From: [REDACTED]
Sent: 22 March 2019 16:05
To: Charlotte Easton
Cc: debi williams
Subject: Re: R7/19/CLP - 9 Hawke Close, Rustington

Scale A1=1:50, A3=1:100
Drawn JHL/SAR
Date 27/11/18
18109-501 F

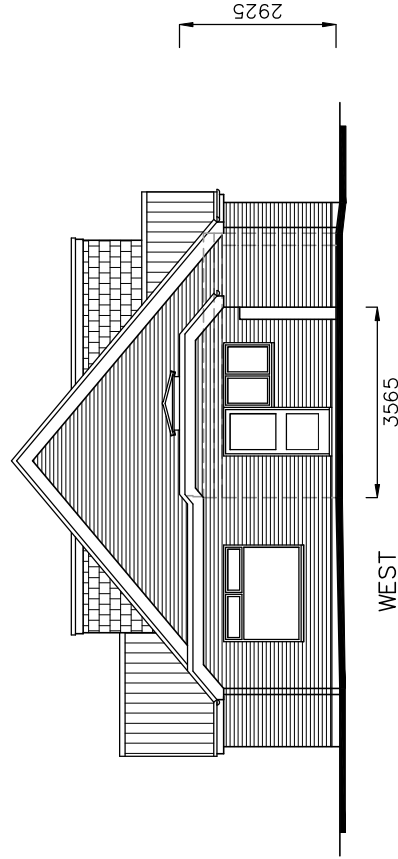
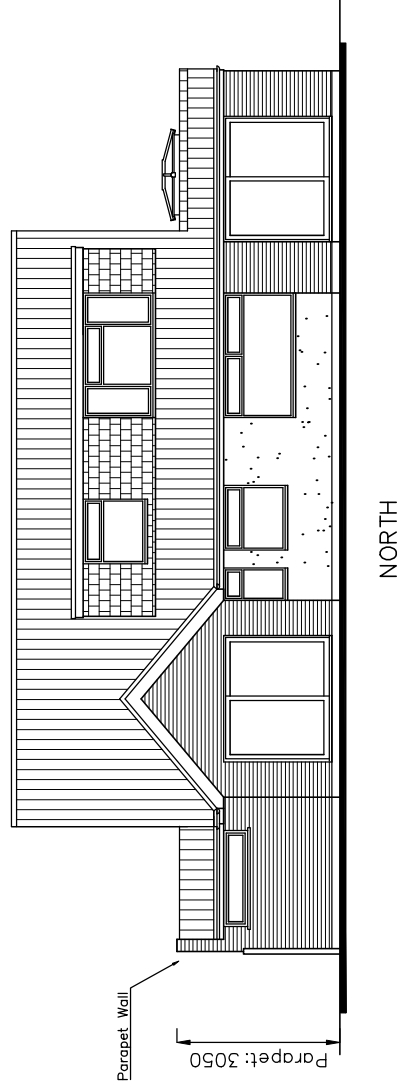
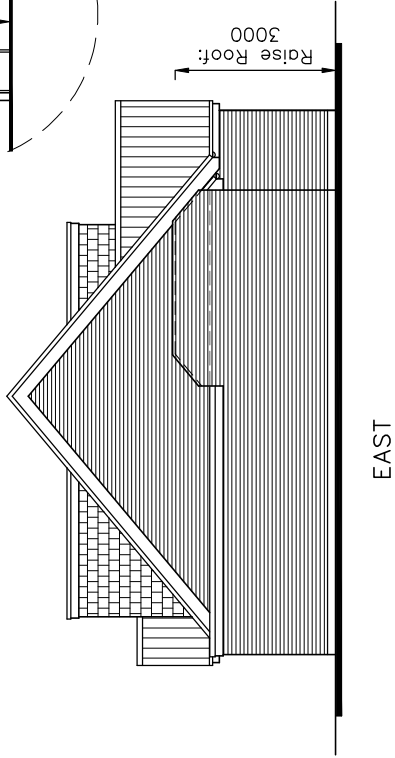
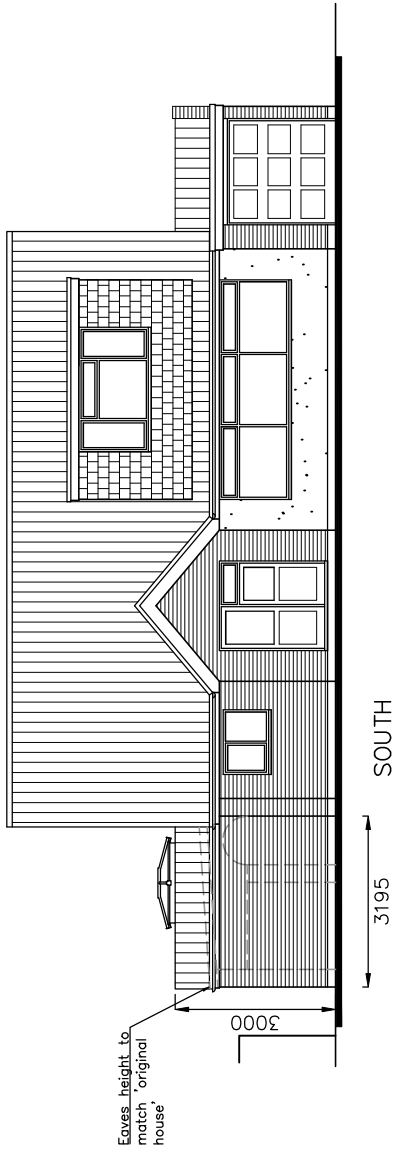
Yes the drawings attached are the ones I have been measuring from, the rear extension measures at 4.1 metres in height.

At present my report would state that permission would be required for the rear extension part of the submission. The plans submitted show the rear extension to be a height of 4.1m which obviously is above the permitted development height of 4m.

Nevertheless, the increased height of the roof (above the wet room) is only proposed to be of 3m height. This is most evident on the East Elevation within drawing 501F.

The rear half of the existing garage is proposed to have a raised roof height of 3m.

The proposed side extension is proposed to have a roof height of 2.925m.

There is no proposed rear extension.
